From Sarah Bucks, chair of the South Somerset Bridleways Association

Response to Deadline 2,

Responses to questions in table 2:

KEY			
LA10, 18 HR [dB] NOISE LEVEL CHANGE			
	<-10		-3<=...<-1
	-10<=...<-5		-1<=...<-1
	-5<=...<-3		1<=...<3
	3<=...<5		5<=...<10
	>=10		HIGHWAYS DESIGN

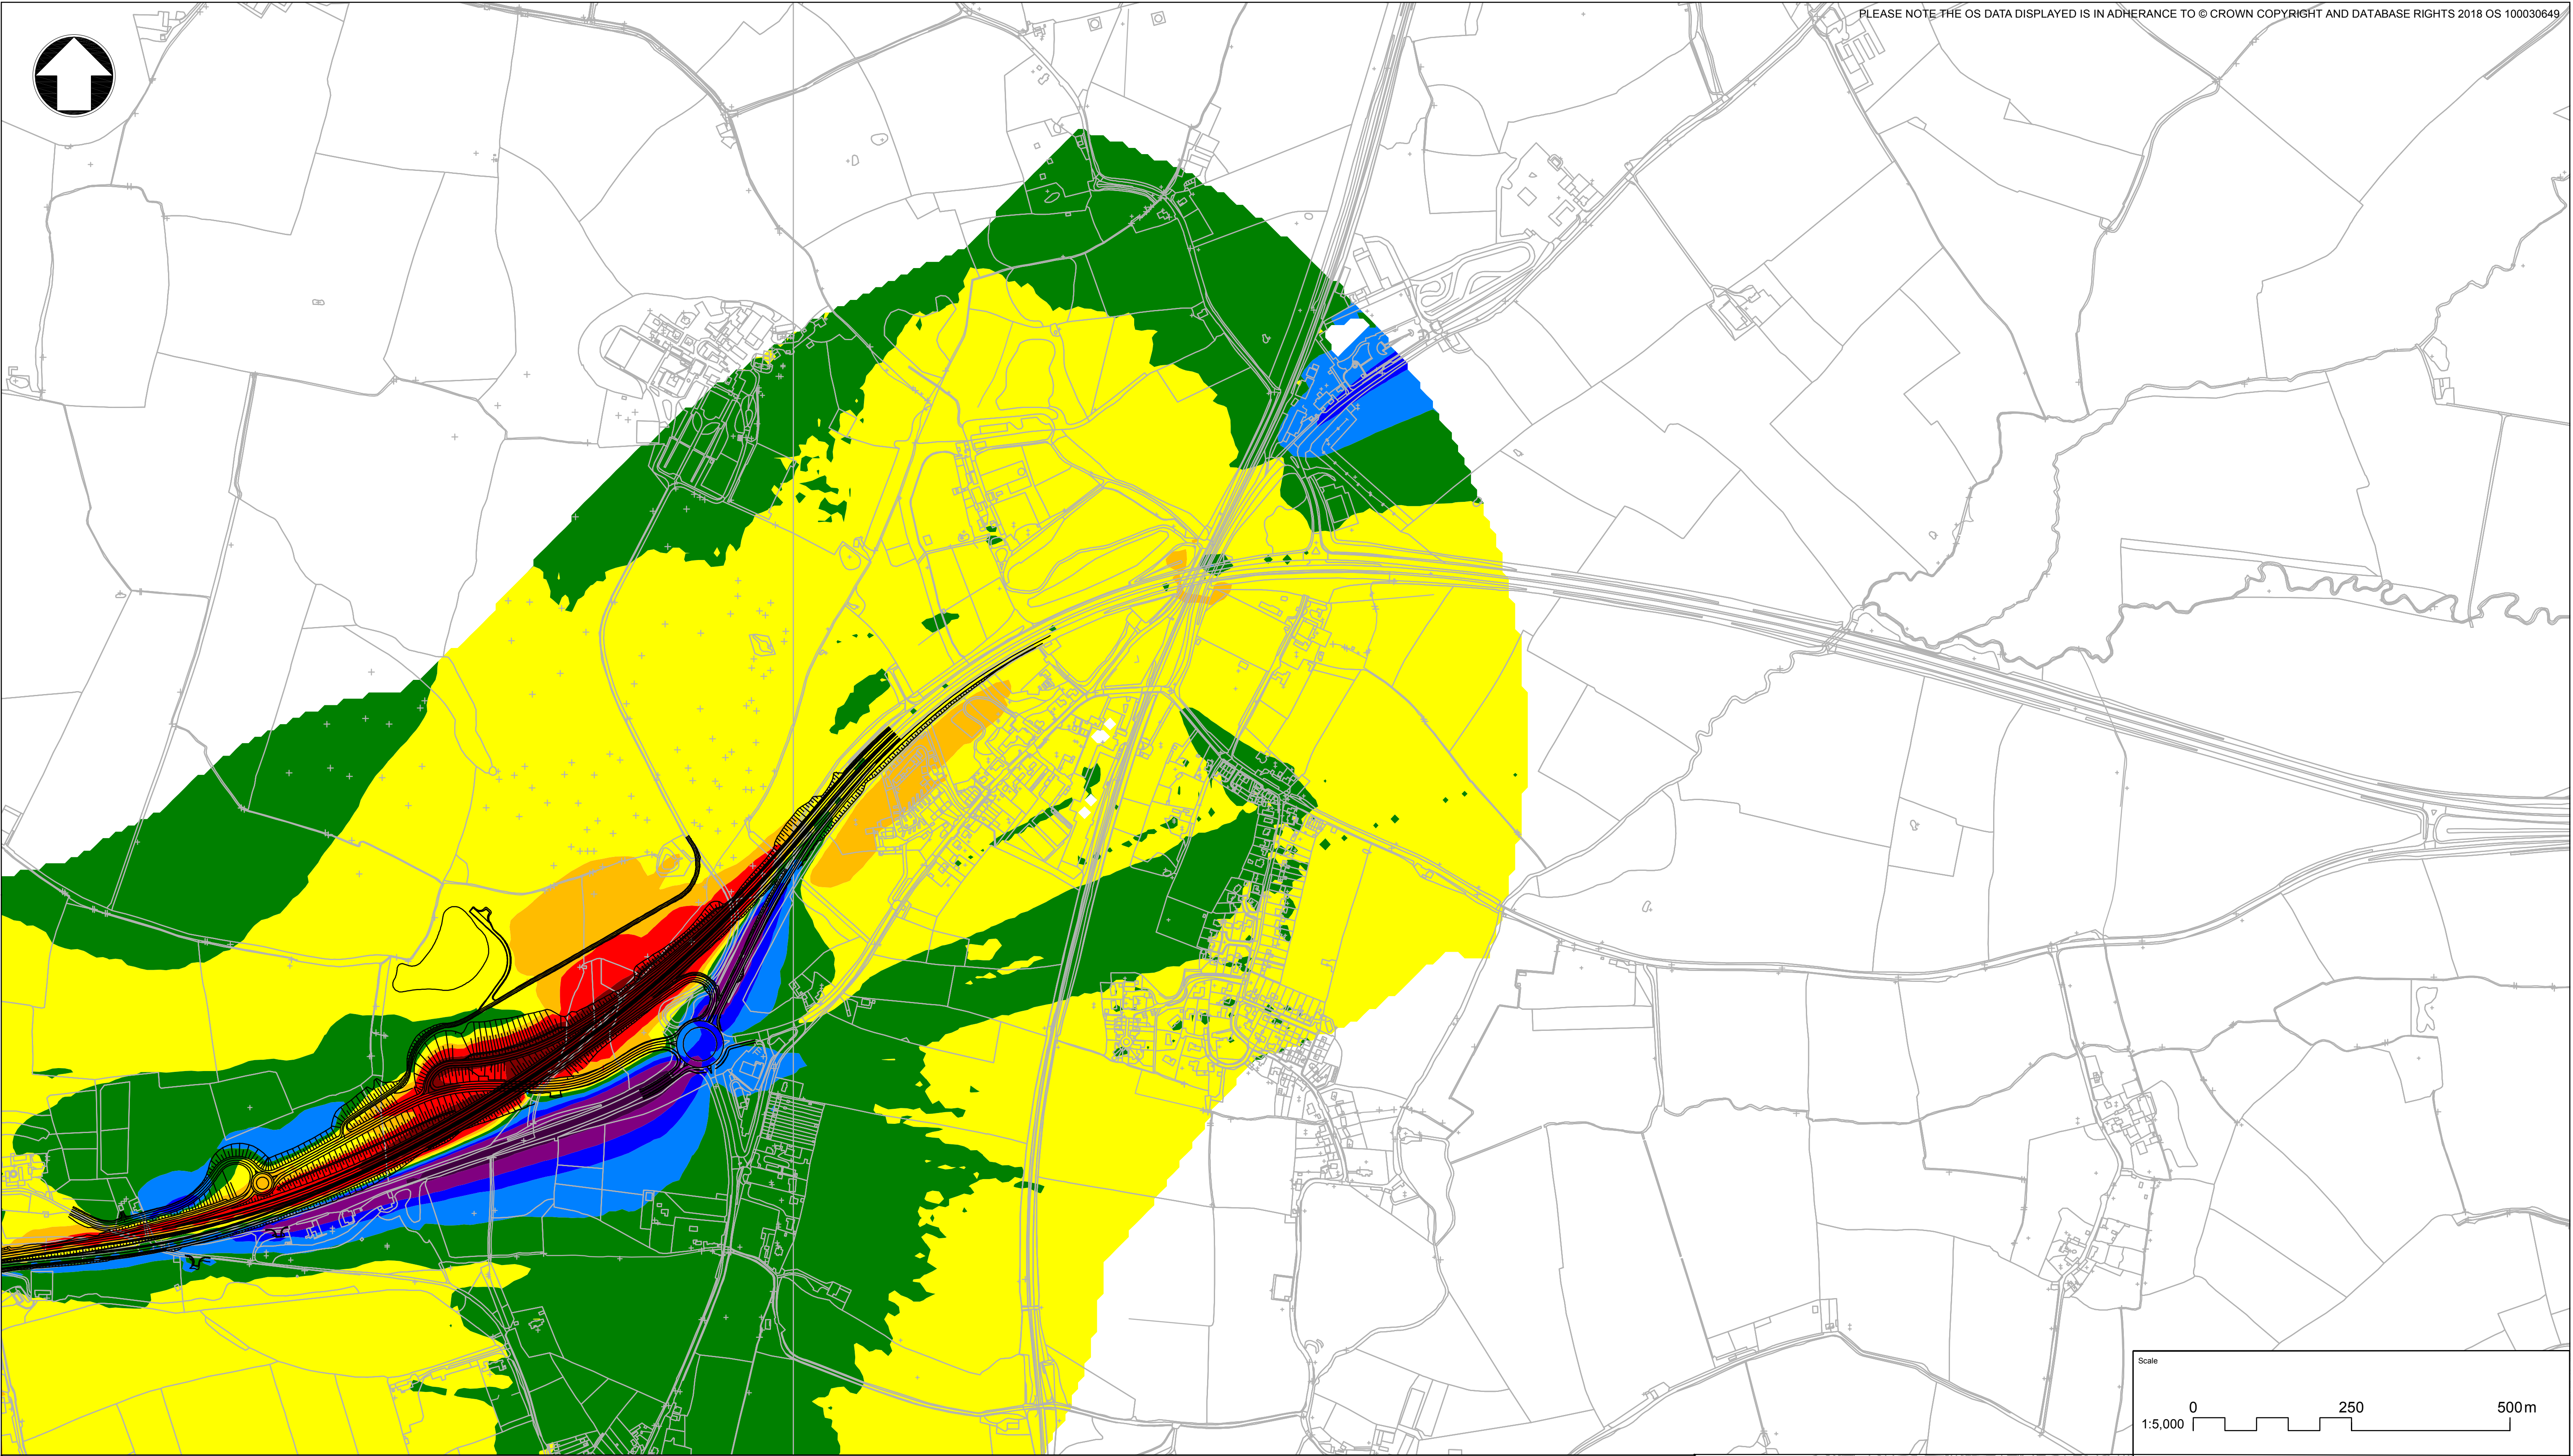
1.4 Road noise along the new carriageway northwest of the Hazlegrove roundabout will impact on the users, including equestrians, of the underpass below. Please could consideration be given to having a low noise surface within the vicinity of the underpass.
